1 No. dwelling with detached garage (part resubmission following R/91/17/PL & R/204/18/PL).

Springfield House Springfield Close Rustington

Thank you for your internet representation made on 13th November 2019 which has been recorded as '**an objection**' with the comments as follows:

FIRST FLOOR PLAN

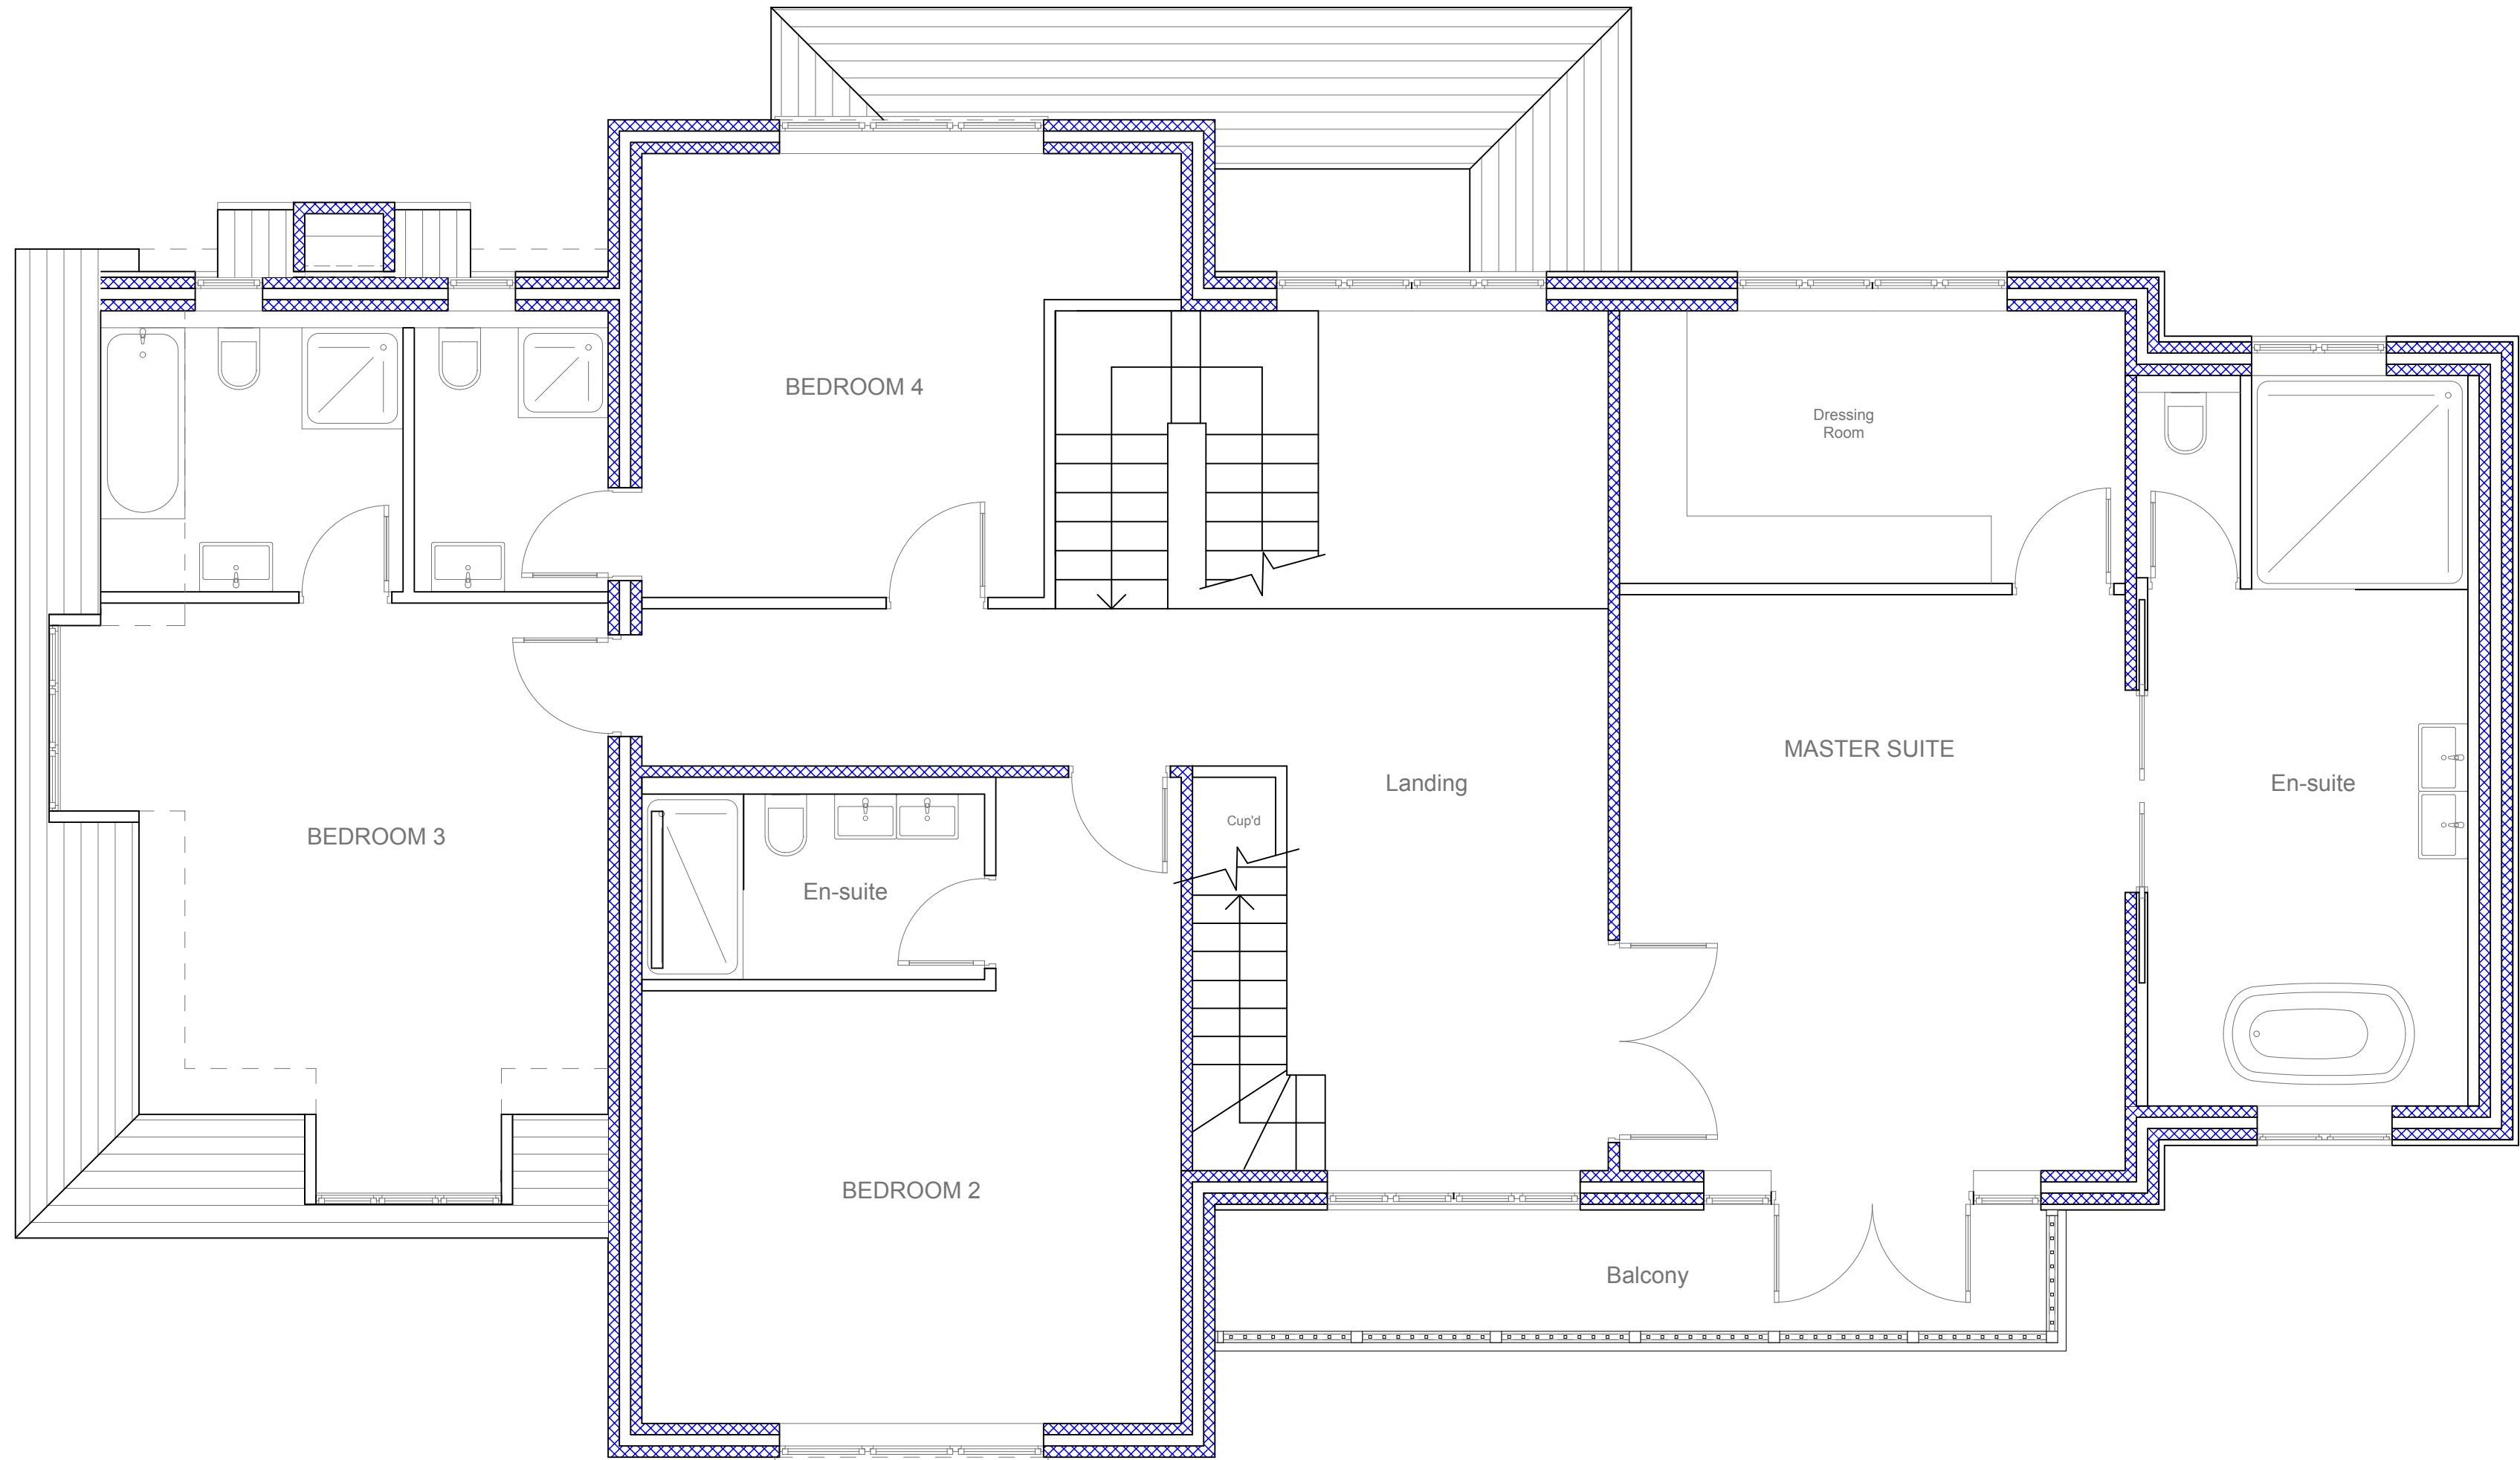
This property is now very different to the original planning application R/91/17/PL. The increased garage, south facing balcony, pool and enlarged paved area will only serve to negatively impact all surrounding properties especially ours.

SECOND FLOOR PLAN

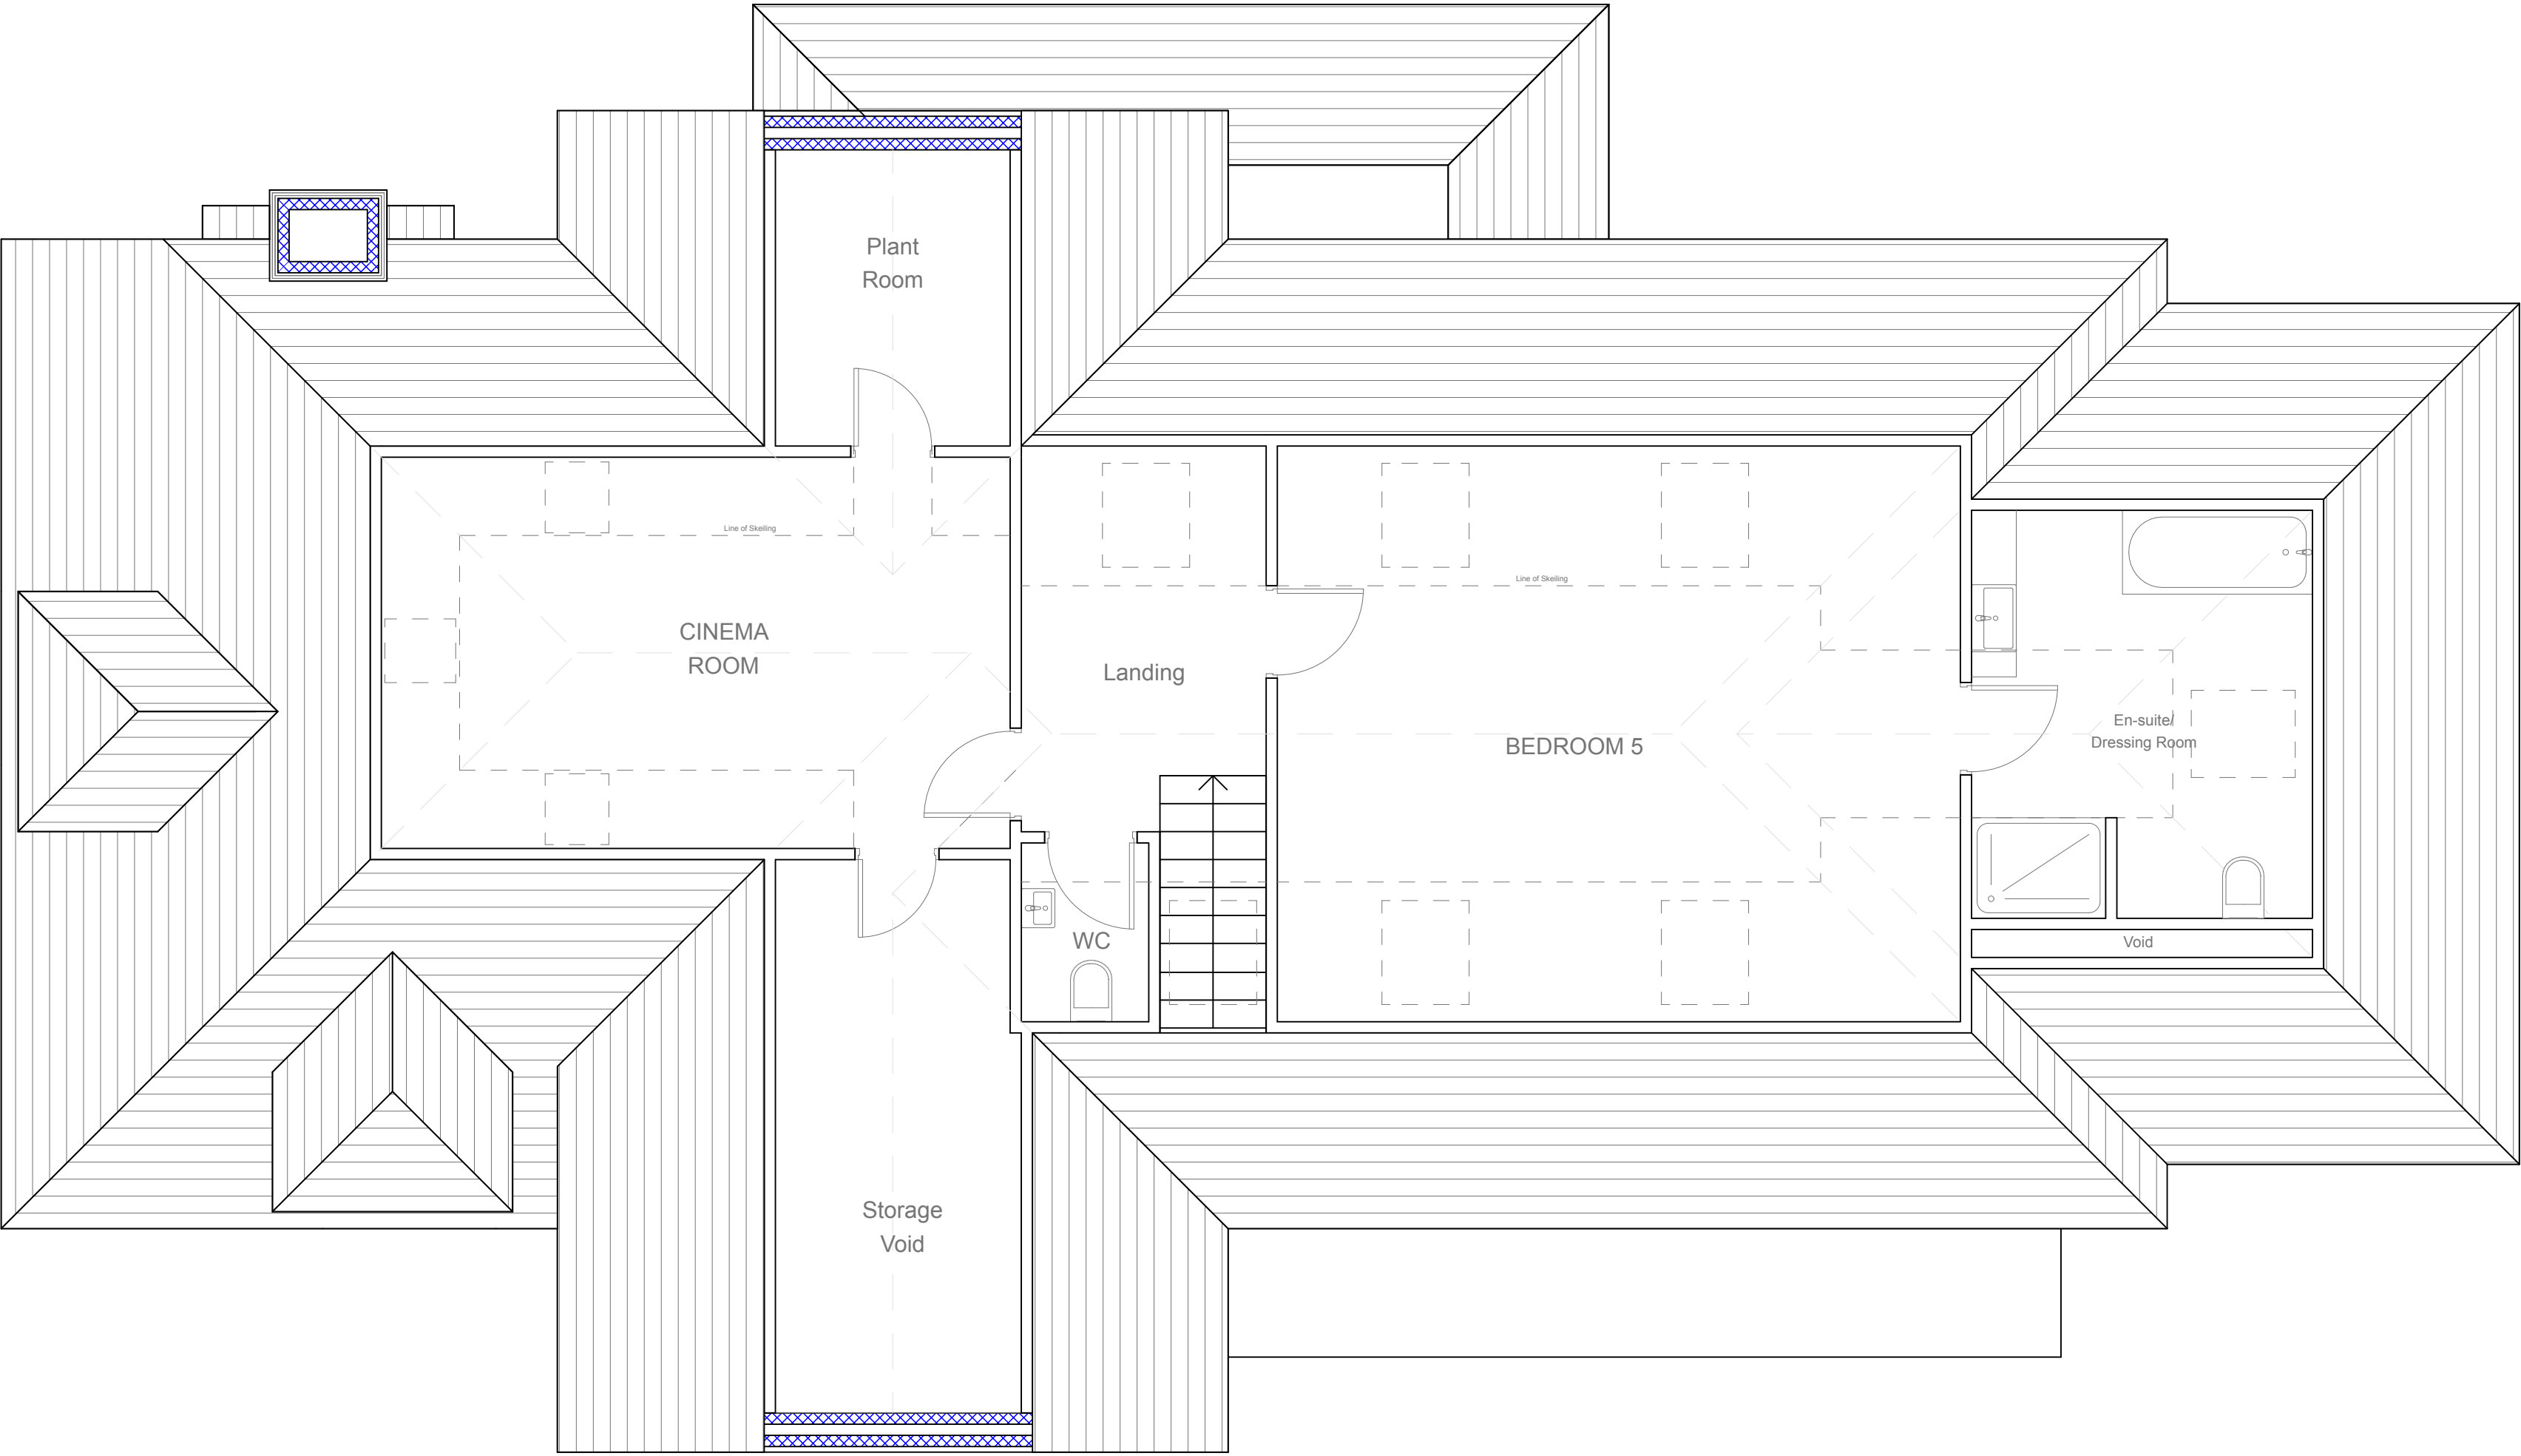
There is now a dormer window instead of a Velux on the third floor facing over our garden. This window was originally meant to be small for a 'plant' room. It is obviously now a bedroom. This window should now be frosted.
